MEMORANDUM

To: FILE
From: Jean Fraser
Subject: Application ID: 2013-228
Date: 12/4/2013

Comments Submitted by: Marge Schmuckal/Zoning on 12/4/2013

Exhibit Sketch For Proposed Conveyance

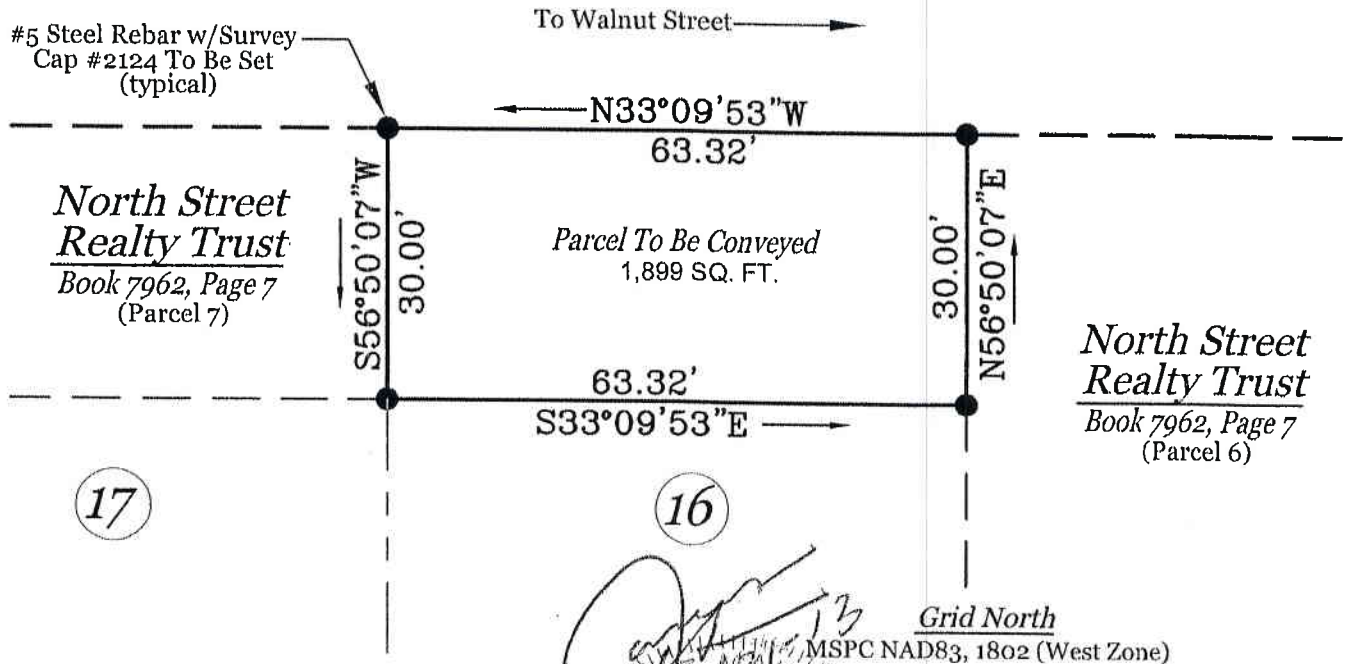
There seem to be two outstanding zoning issues that Marge needed addressed. The first relates to the bumpout on the rear of the building at 128 North Street. It appears that this "bumpout " is a bulkhead which encroaches into the 20' rear yard setback. Section 14-425 allows a "basement bulkhead" whose area does not exceed 50 square feet and which does not project more than 6' from the principal structure to encroach into any required yard setback. The section also stipulates that the bulkhead may not be more than 24 inches in height. If the bulkhead at 128 North Street meets this criteria, then the proposed lot line meets zoning.

The second issue is the utility closet which encroaches into the 20 rear yard setback. Section 14-139(a)(4)(b) states that the rear setback for "principal and attached accessory structures with ground coverage greater than one hundred (100) square feet" is 20 feet. When the accessory structure is attached to the principal structure, it is part of the principal structure and therefore the ground coverage includes the footprint of the principal structure and the attached accessory structure. Since the footprint of both together is over 100 square feet, the utility closet needs to meet the 20' rear setback. At this point it does not. - Ann Machado
